Plat V-1.pdf Markup Summary

TIS V_1.pdf Markup Summary

CD V_1.pdf Markup Summary

SHEET 1 OF 8

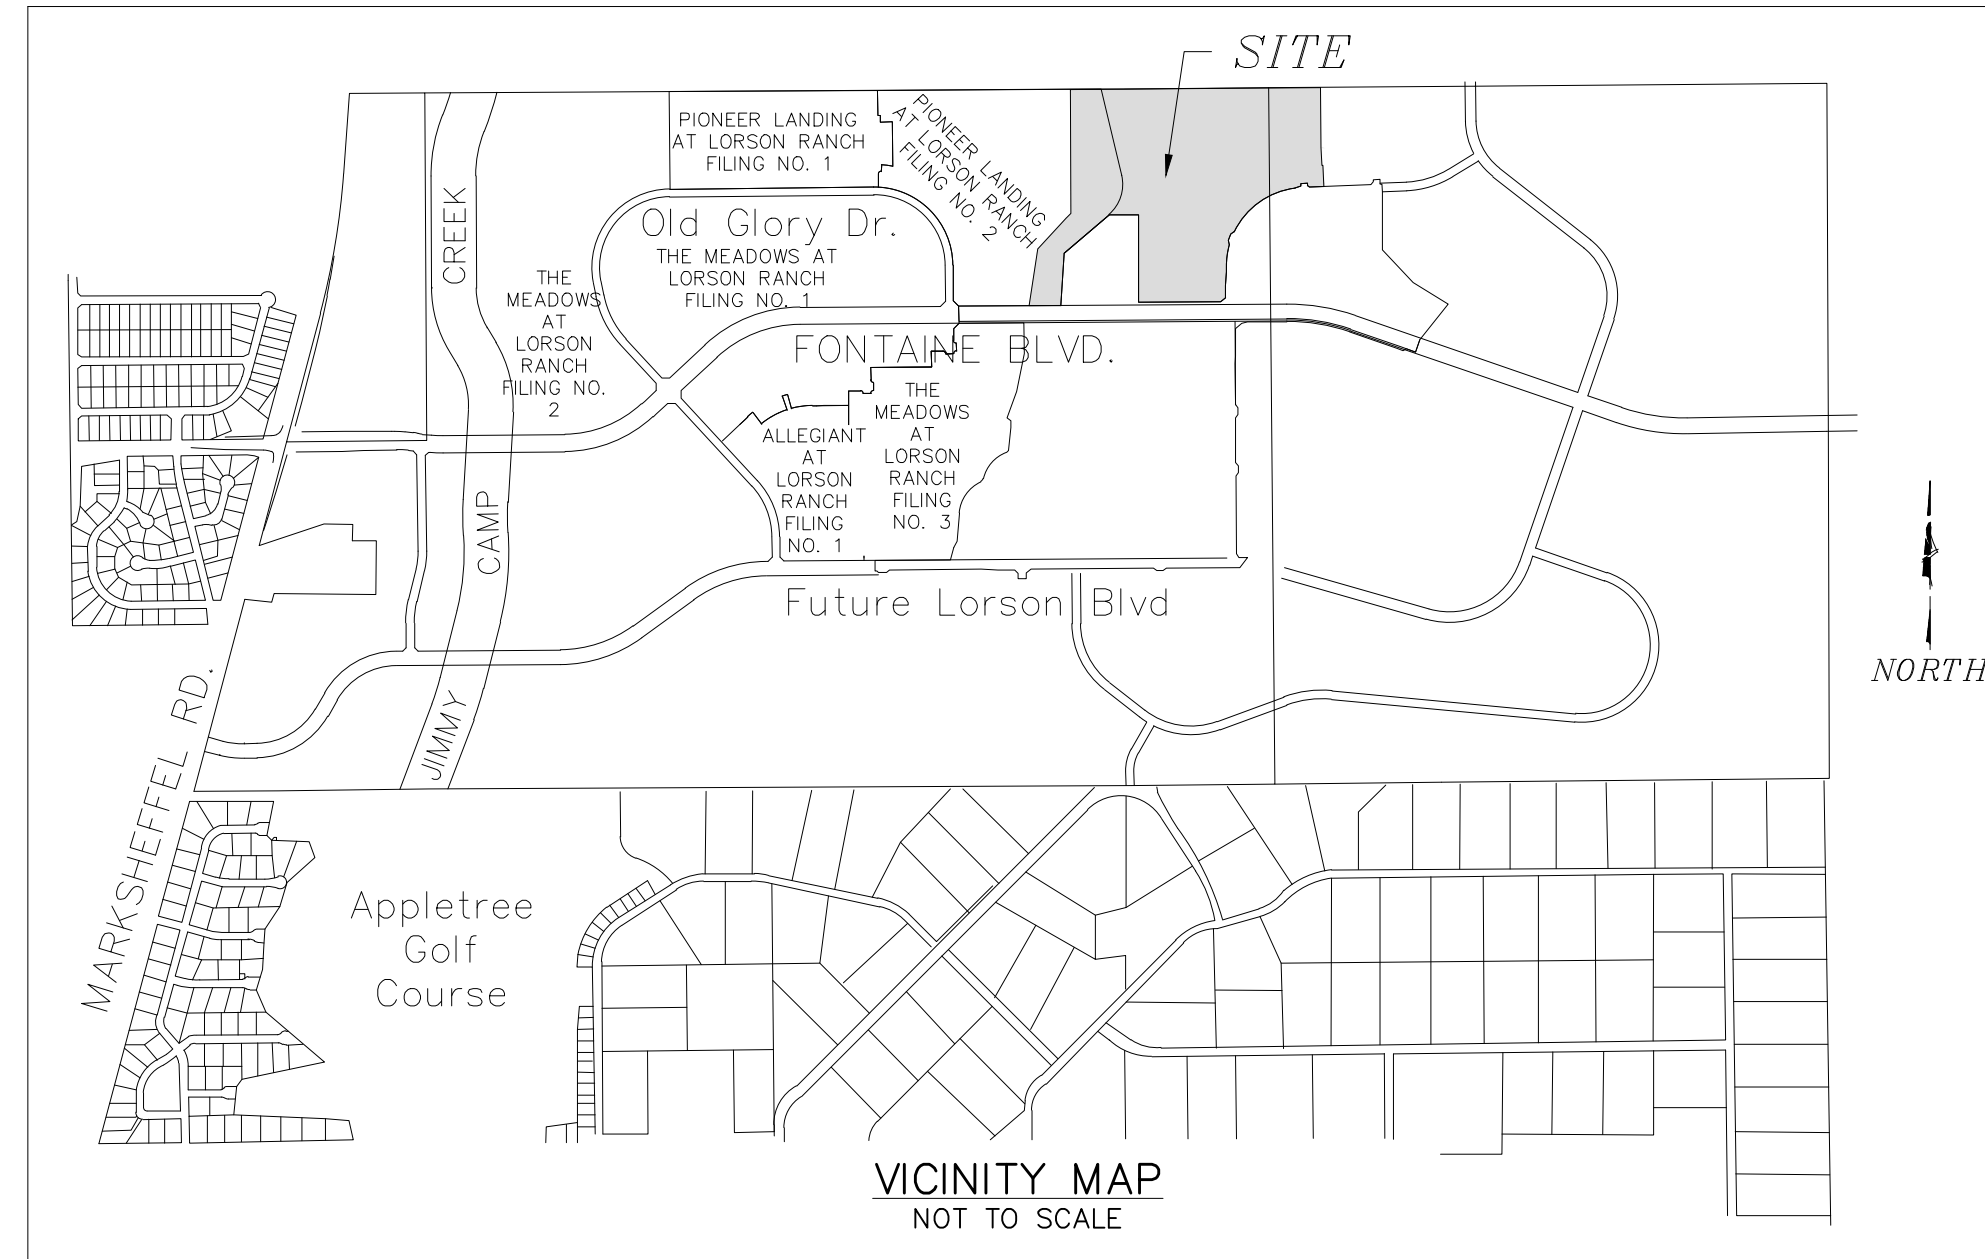
Add 2018 LOMC number when available

Please work with Gilbert :aForce on credits. His number may be different. 5207945

Please use a varying line type for the plat boundary on all sheets. It is very difficult to delineate what is in this plat and what is not.

SHEET 2 OF 8

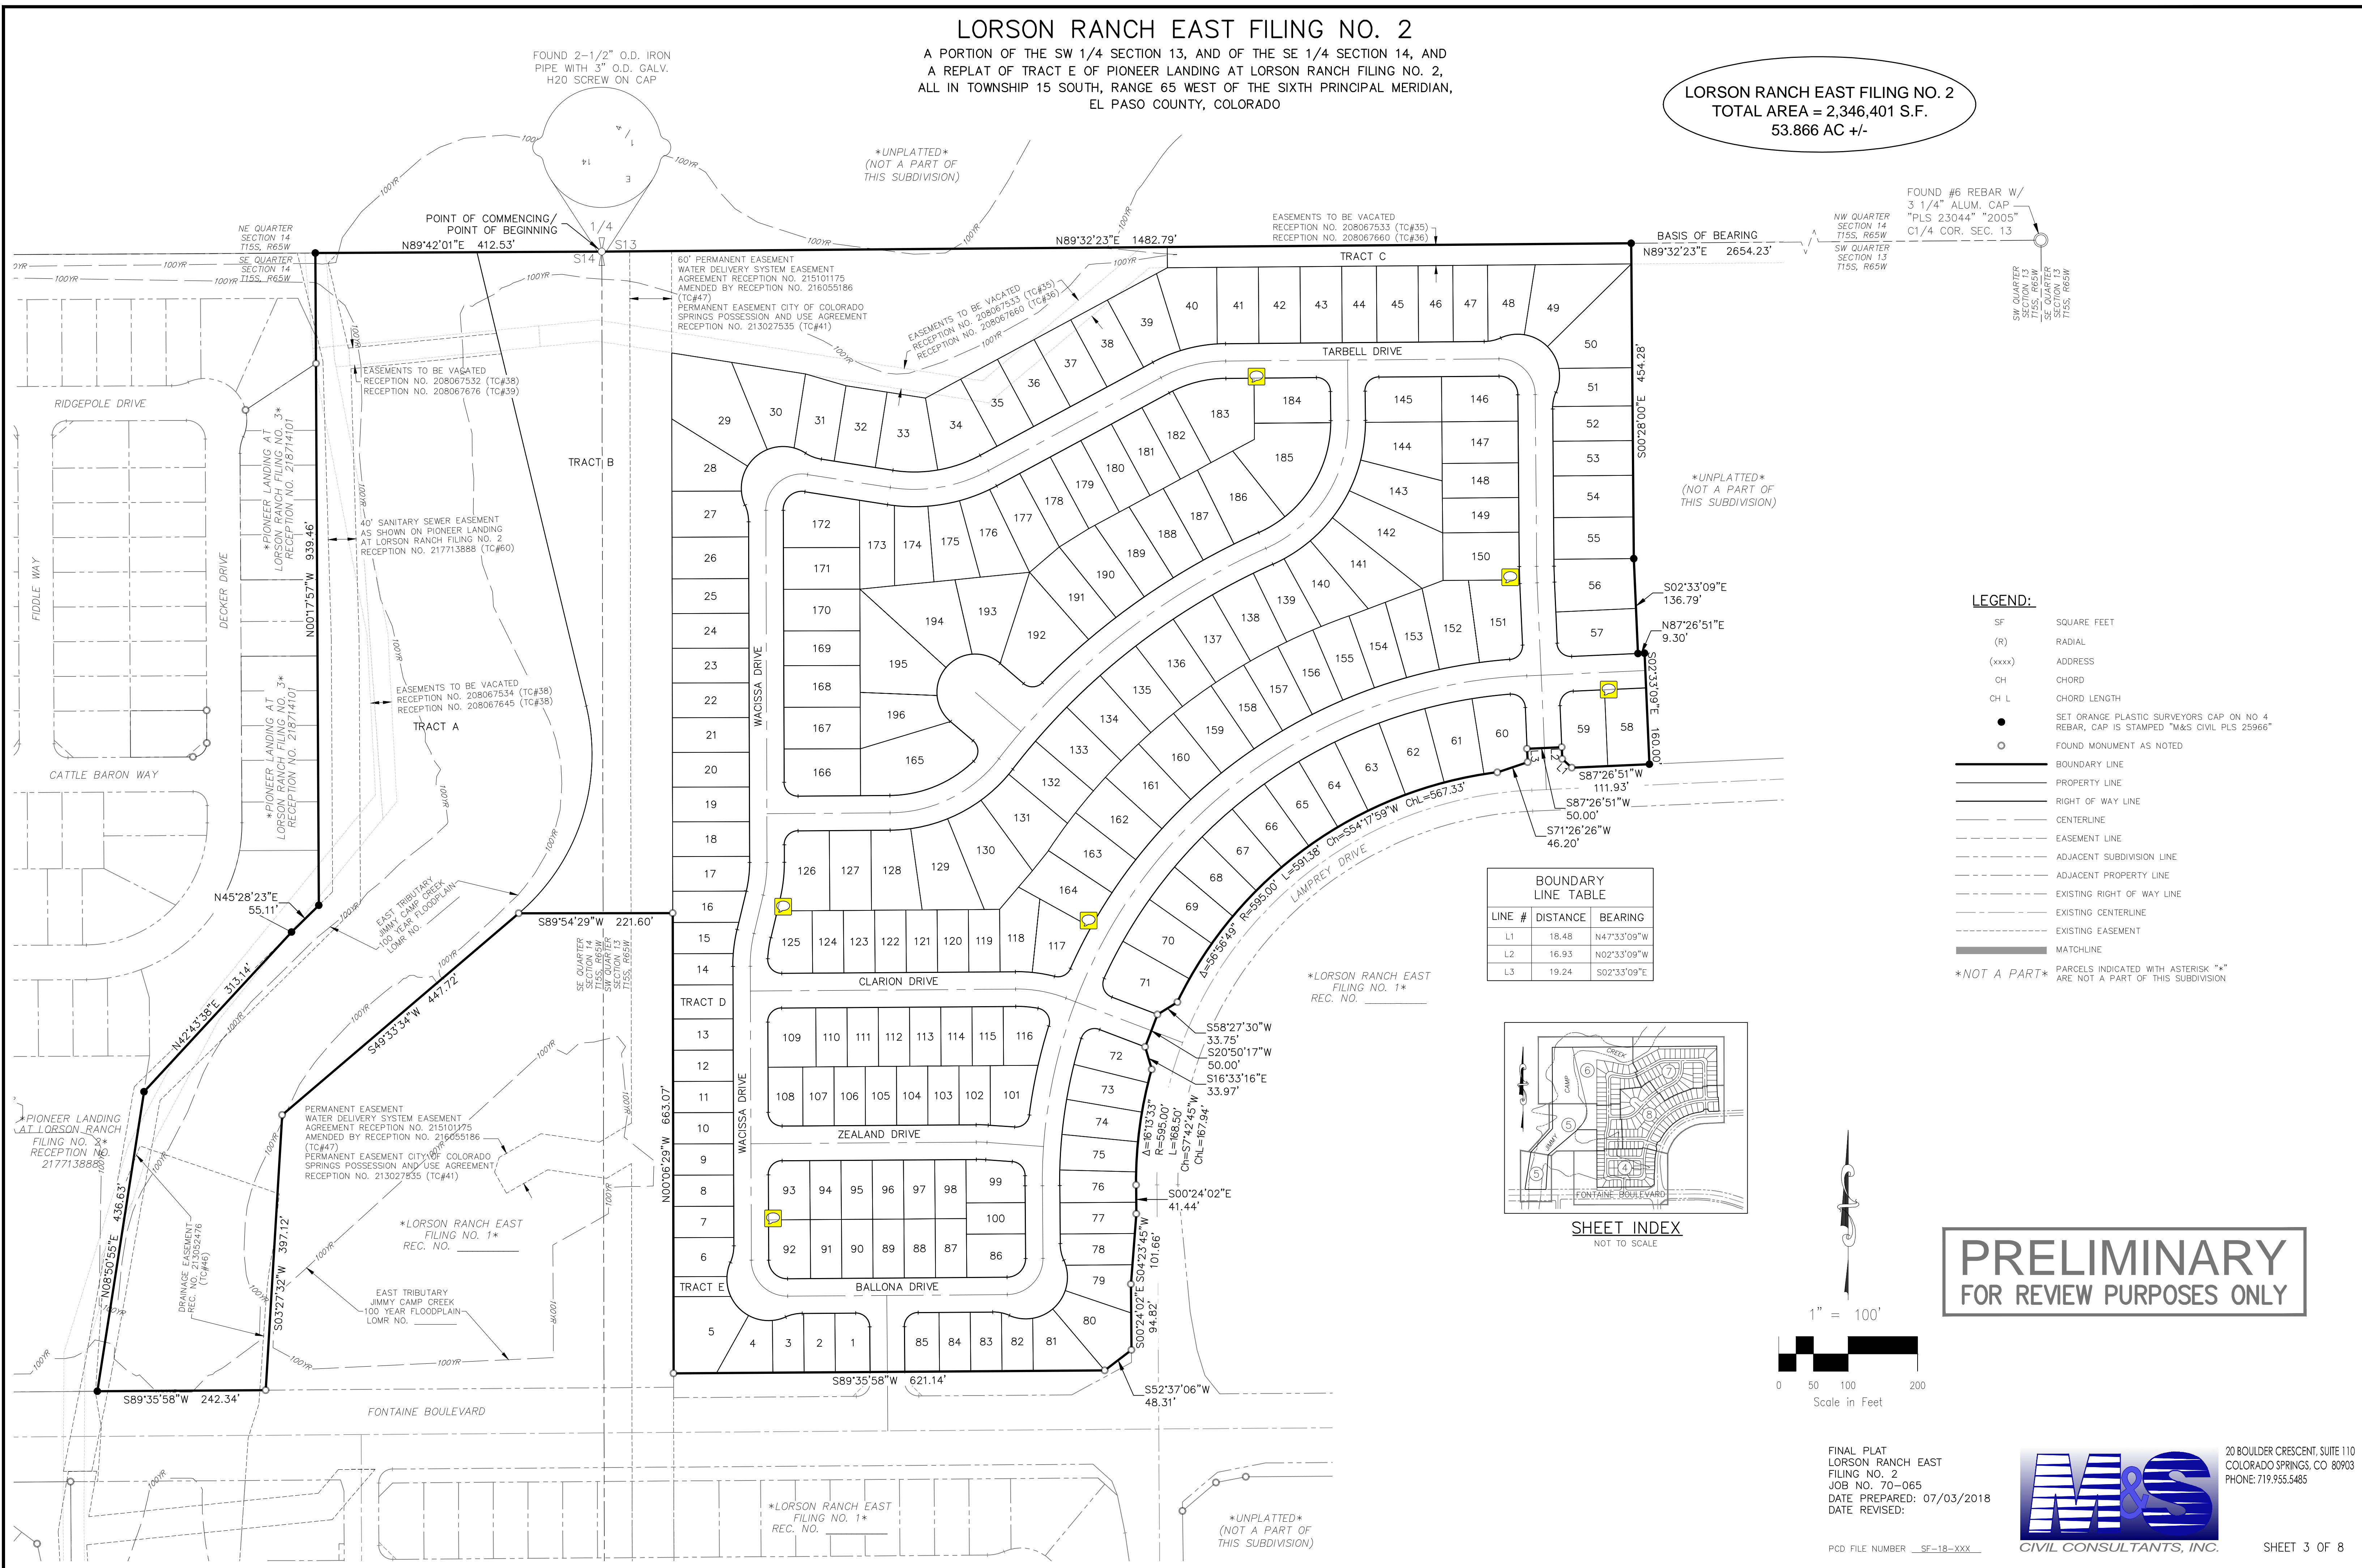
Add note:
Lots 29-39 shall require an engineered site plan, prior to obtaining a building permit, showing that all building and lot elevations are greater than those specified on the detailed "minimum required elevation" grading plan.

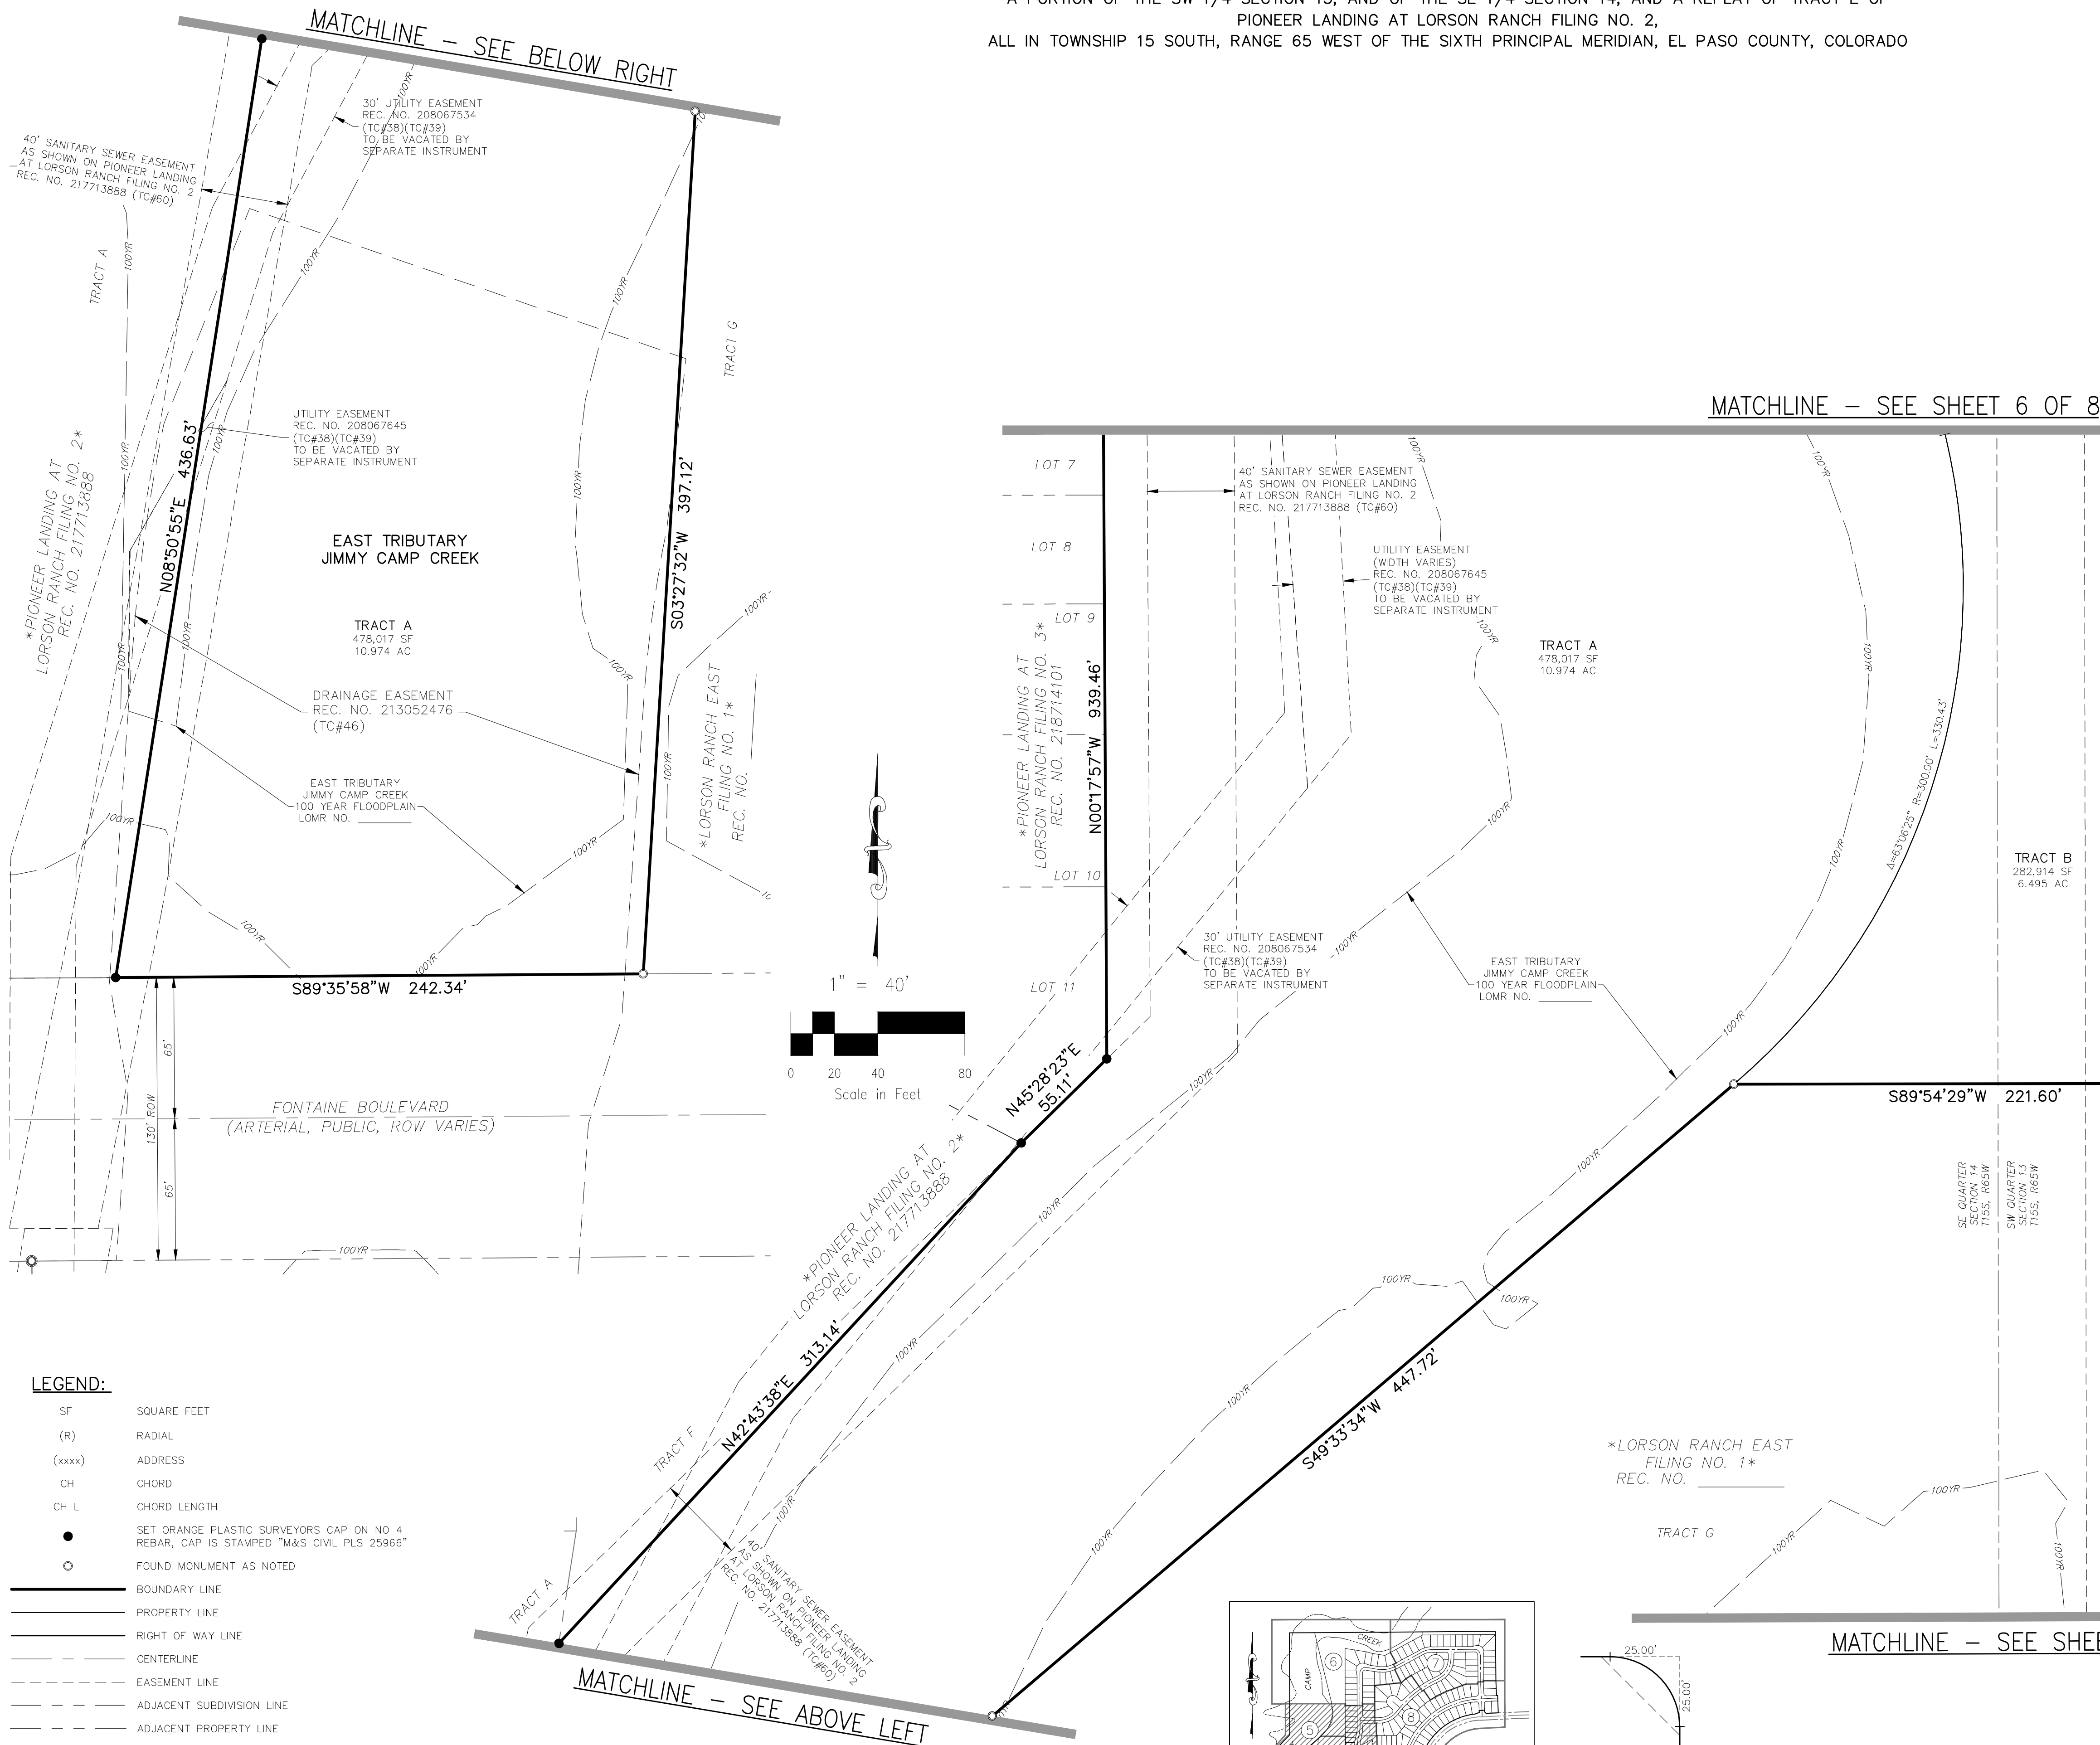
TRACT B

Thicken Subdivision boundary line
